Pre-Examination Stage – DRAFT ECOLOGICAL COMMENTS

Figure 2 – NVC Communities within Denmead Meadows and Kings Pond Meadow SINC

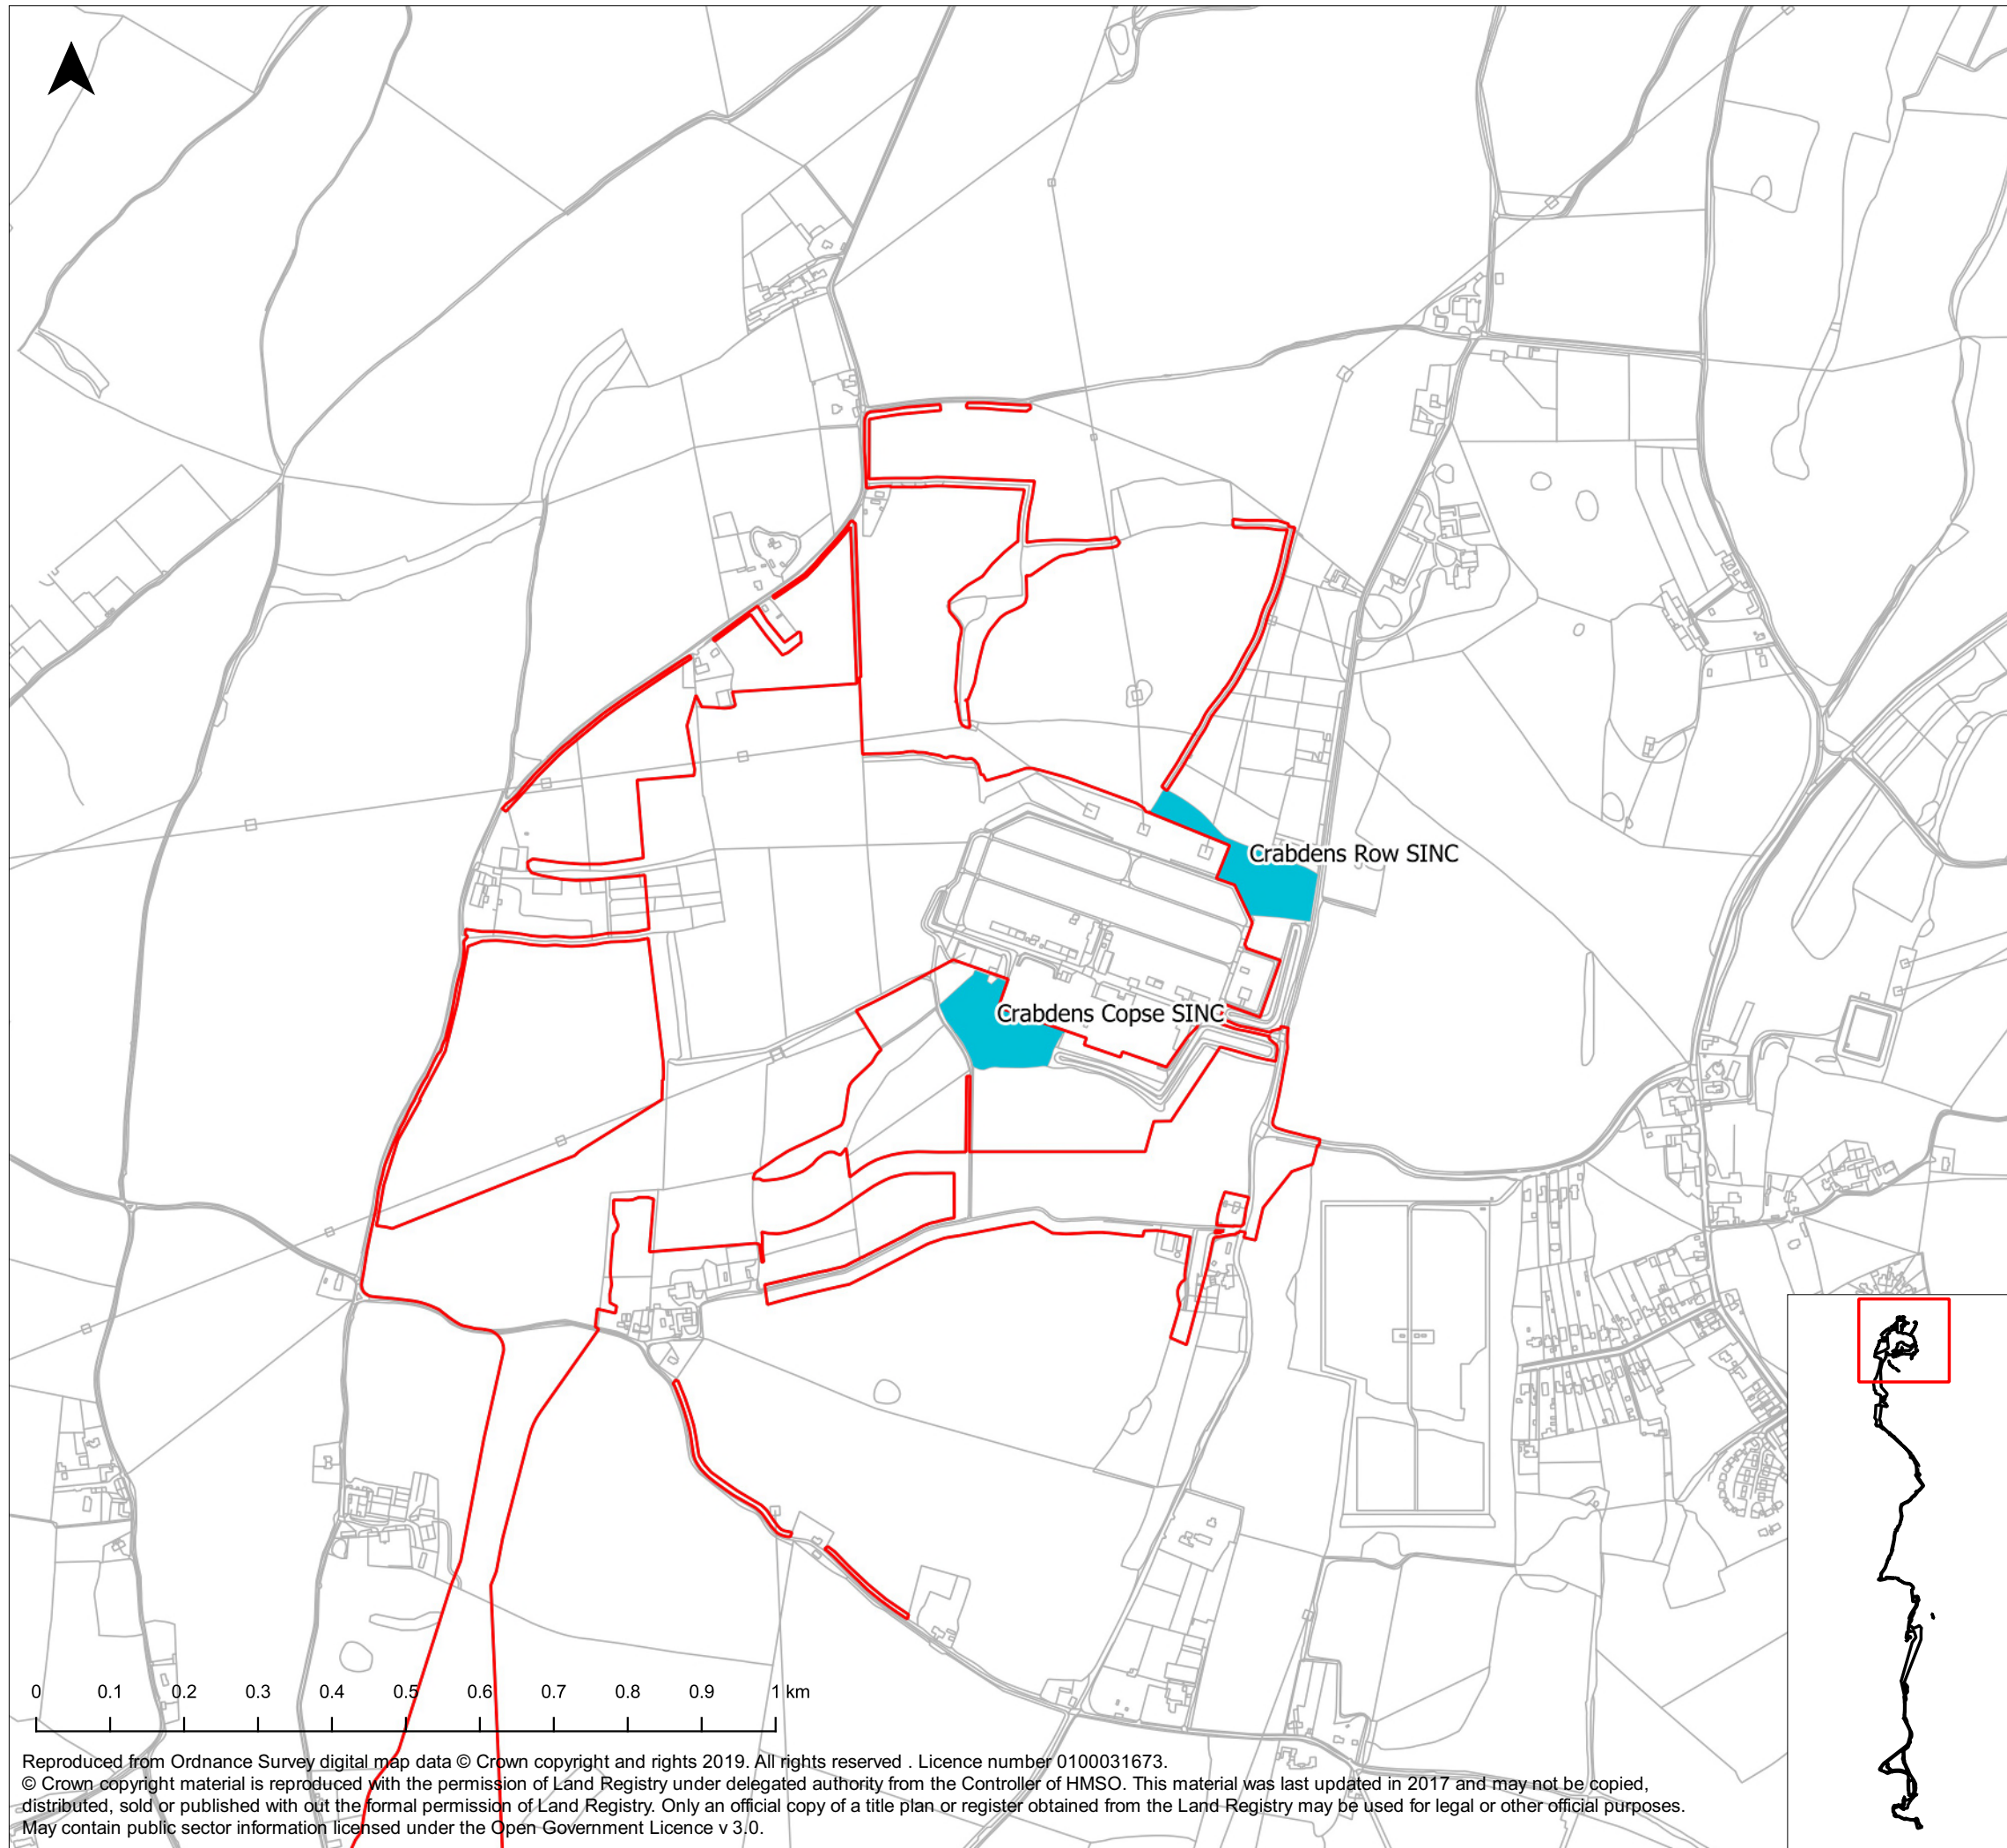
Has botanical survey been considered in certain areas such as Denmead Meadows where there is significant importance including the Kings Pond meadow SINC which hosts a regionally-important Green-winged orchid site (classified as Near Threatened on the Vascular Plant red Data List for Great Britain).

Section 16.5.1.3. Agricultural pasture south of Kings Pond Meadow SINC (see below for description) comprises unimproved grassland enclosed by species-rich hedgerows (some with trees), known as ‘Denmead Meadows’. All fields within Denmead Meadows are hay meadows left un-grazed, and surveys by both WSP and wildlife groups (Appendix 16.4 (Non-Statutory Designated Sites Report) of the ES Volume 3 (document reference 6.3.16.4)) have revealed them to be botanically diverse, supporting important plants such as green-winged orchid and adders-tongue fern. In addition, plants characteristic of wet meadows are present due to the water course that flows through this area from Kings Pond SINC. 16.5.1.4. Botanical survey work undertaken in July 2019 (Appendix 16.4 (Non-Statutory Designated Sites Report)) showed the plant community in all fields comprising Denmead Meadows conforms to the “Lowland Meadow” HPI designation under Section 41 of the NERC Act 2006. Kings Pond Meadow is classified as important at the County scale.
